Date: 9 August 2018

Planning Act 2008 – Section 51

Application by Suffolk County Council for an Order Granting Development Consent for the Lake Lothing Third Crossing

Advice following issue of decision to accept the application for examination

DRAWING: **Section B-B (through core)**

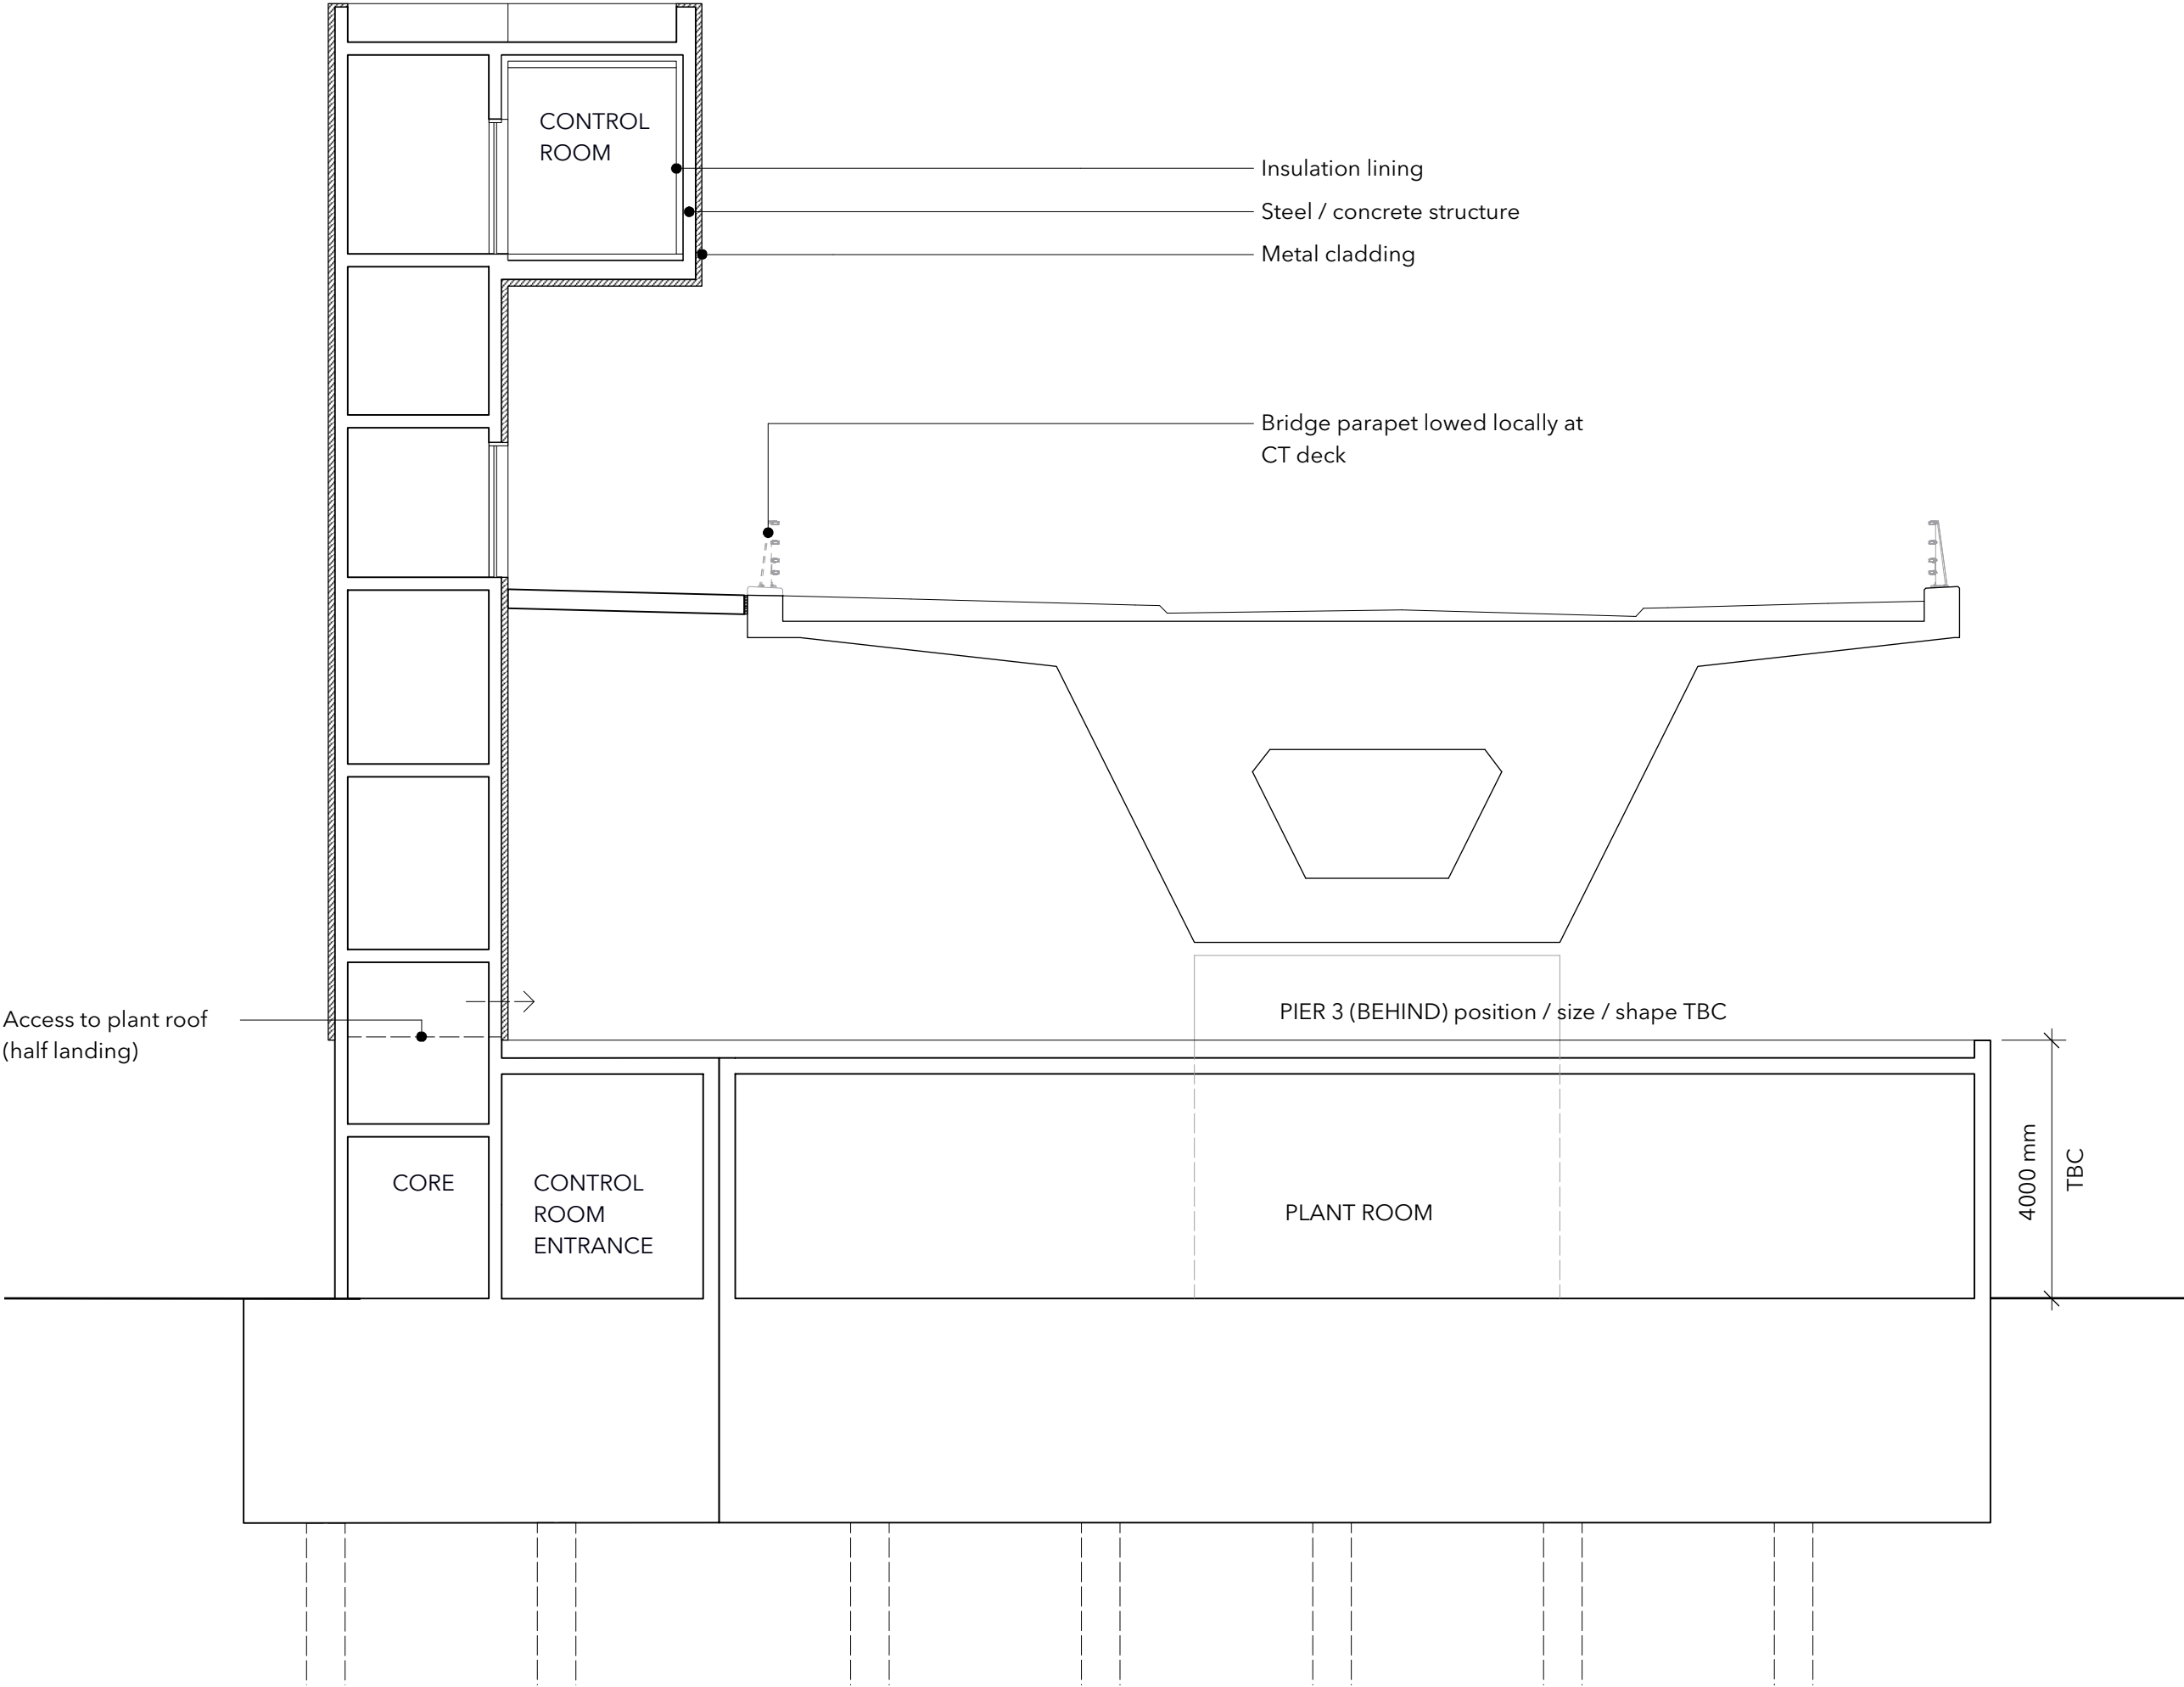
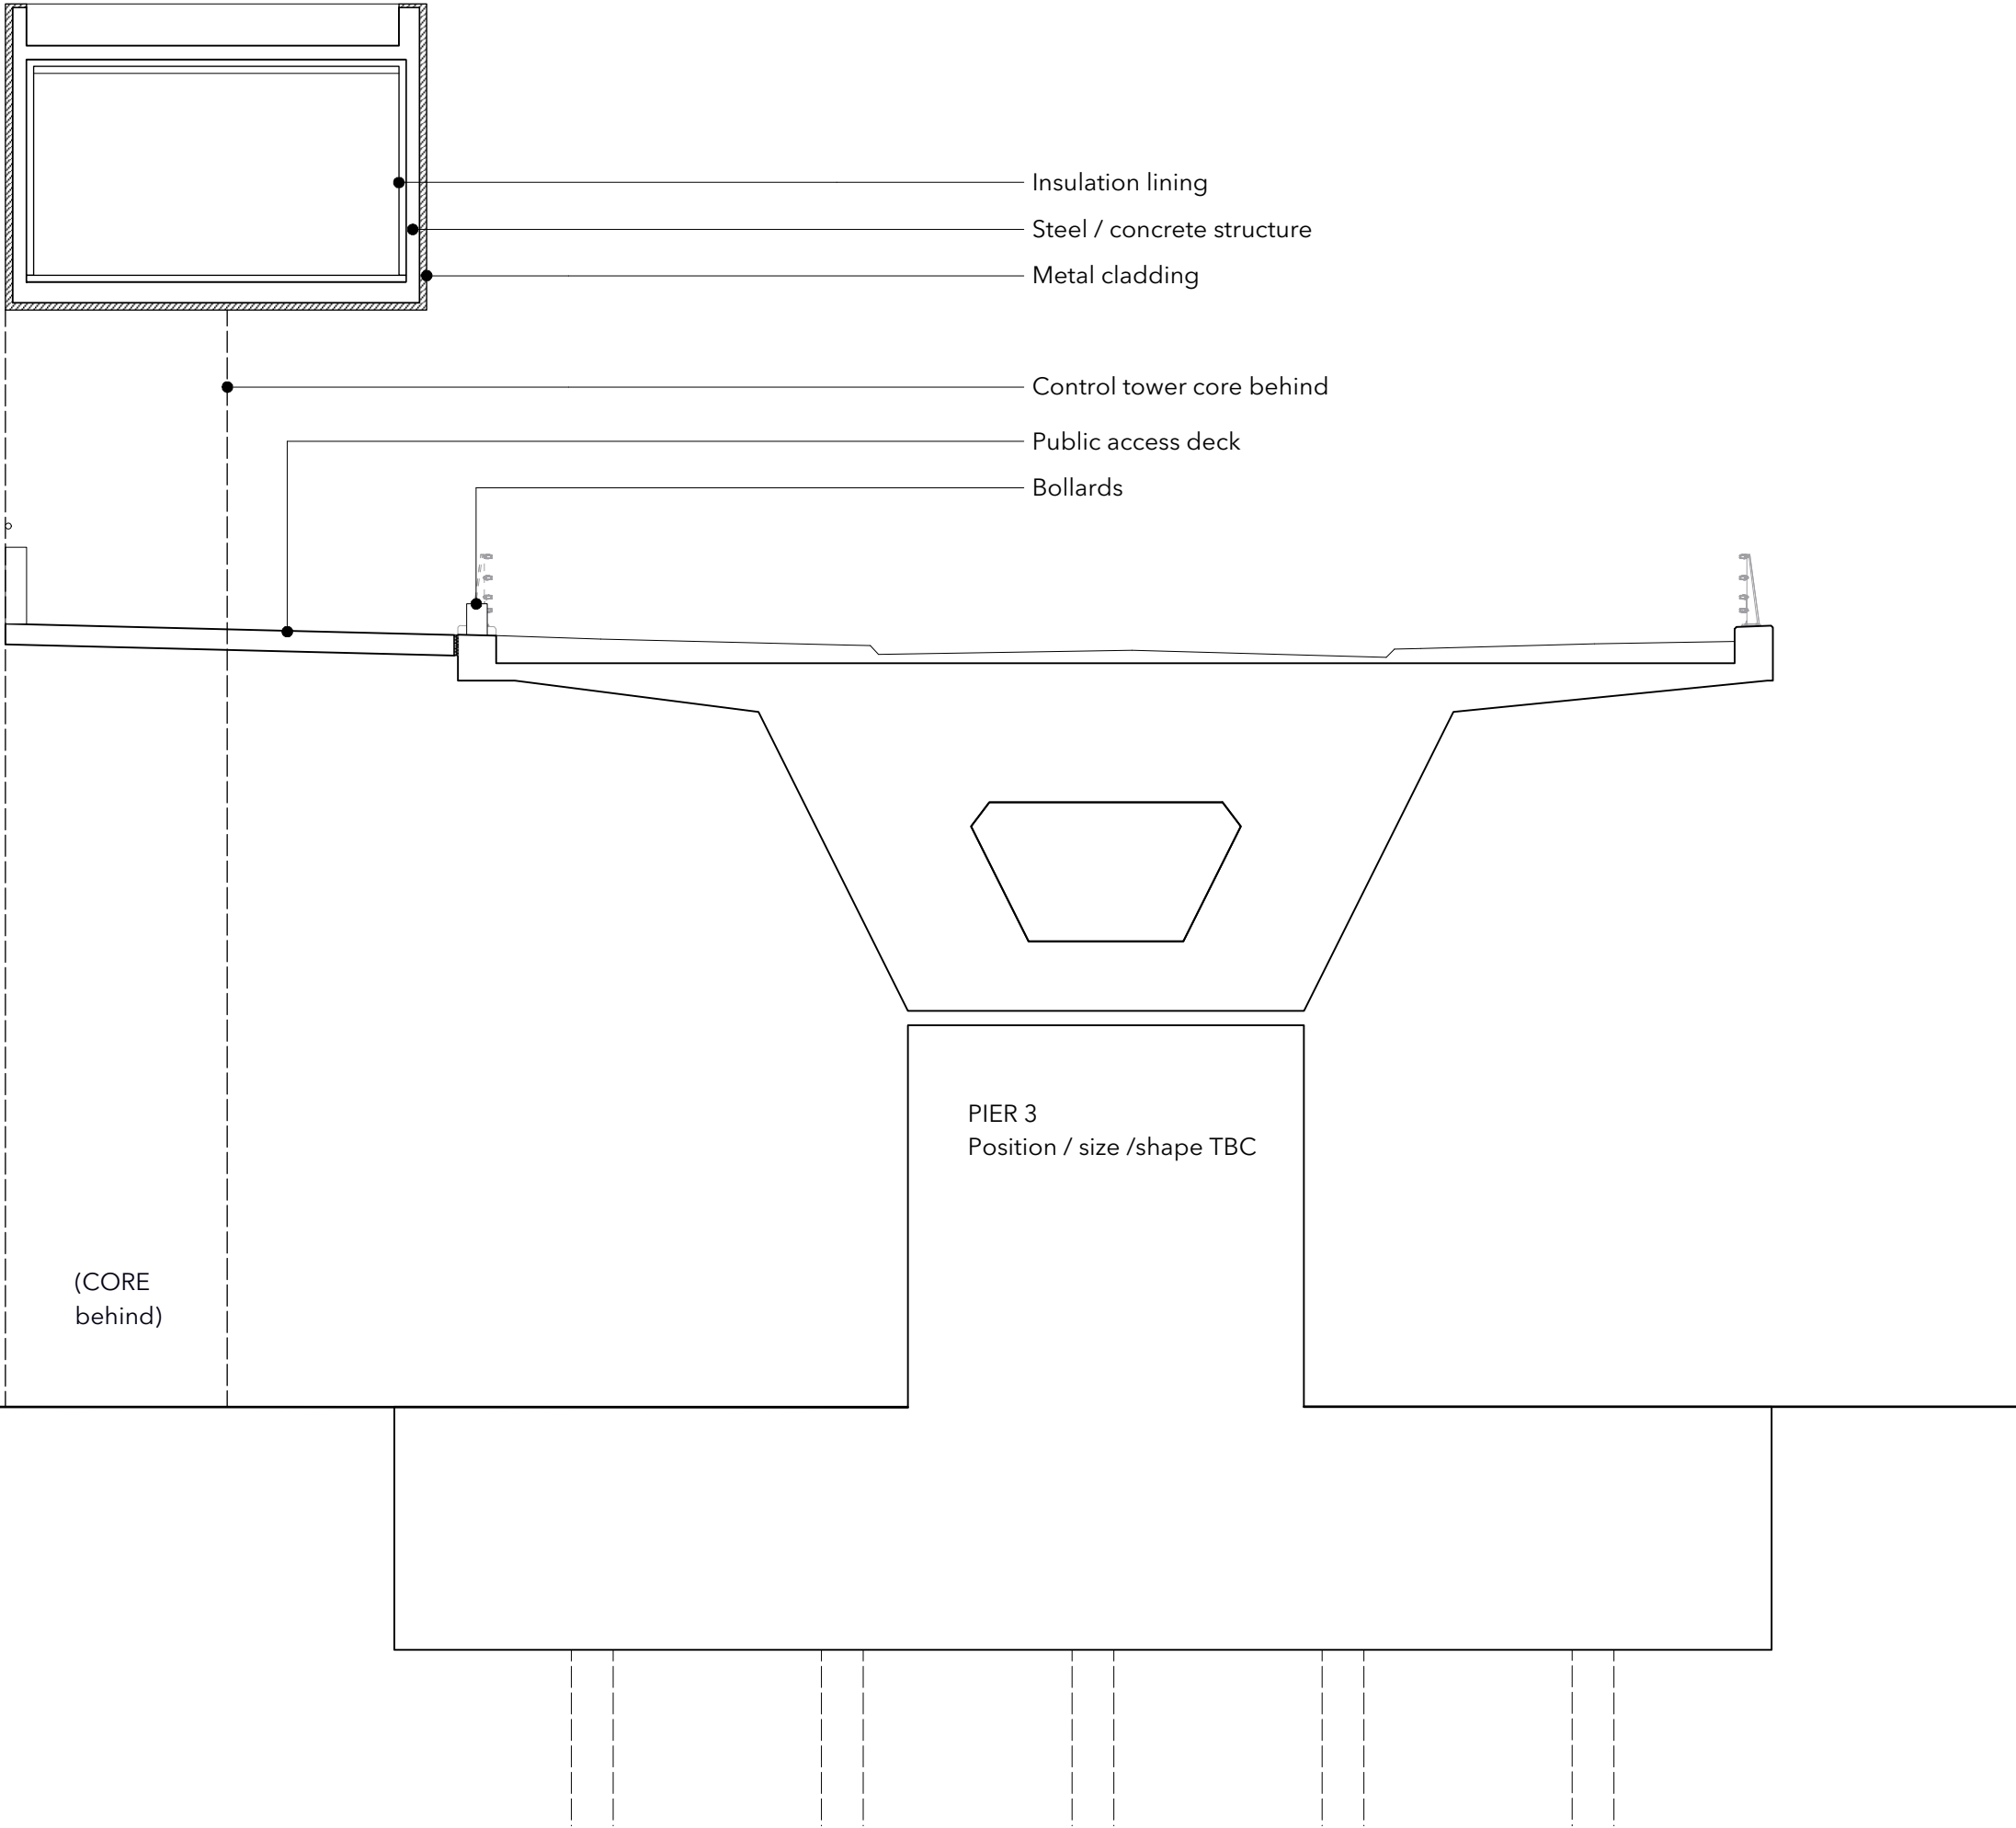
The Applicant is advised that the appointed ExA may request for the provision/ preparation of detailed technical plans and elevations for the design of the bridge, the bridge abutments and the control tower to inform the examination of design matters.
